**KIRKLEES METROPOLITAN COUNCIL
INVESTMENT & REGENERATION SERVICE**

**DELEGATED DECISION FOR APPLICATION FOR CERTIFICATE OF
LAWFUL DEVELOPMENT**

Reference no.: 2025/CL/91438/W

Site: 7, Old Hopkinson Drive, Birkby, Huddersfield, HD2
2FU

Title: PROPOSED ELEVATIONS

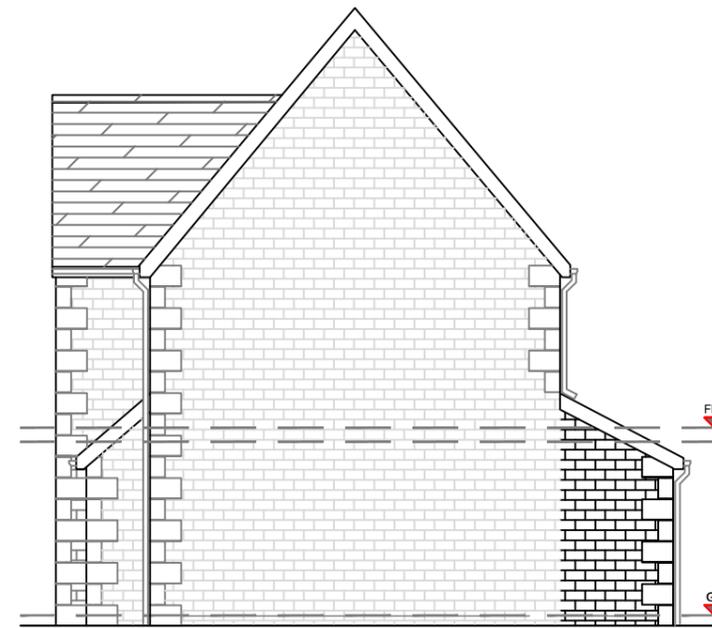
The extensions would attach the existing and 'original' reward projection and would project off both side elevations of the projection to result in a full width extension lying flush with the existing. The total projection would be 1.6 metres with an eaves height of 2.3 metres and an overall height of 3.3 metres to the ridge of the lean-to roof.

Comment: *The plans for the property which granted permission for the dwellinghouse are available to be viewed online. The dwellinghouse, as approved and constructed has a rearward projection facing northerly. Other properties within the cul-de-sac have similar features. The proposed development would enlarge the property to both sides of the rearward projection resulting in a rear projection extending the entire northern elevation of the property. However, each side enlargement extends beyond the existing original side elevation resulting in two enlarged parts, each not measuring more than half the width of the original dwellinghouse.*

Comment: *The property is on article 2(3) land and would extend beyond a wall forming a side elevation of the original property.*

The proposed rear storey extension would not benefit from a general planning permission under Article 3(1) and Schedule 2, Part 1, Class A of the Town and Country Planning (General Permitted Development) (England) Order 2015 (as amended) as the dwellinghouse is located on article 2(3) land (conservation area) and the proposed enlargements would extend beyond a wall(s) forming the side elevation(s) of the original dwellinghouse contrary to sub-paragraph A.2 (b) of Class A.
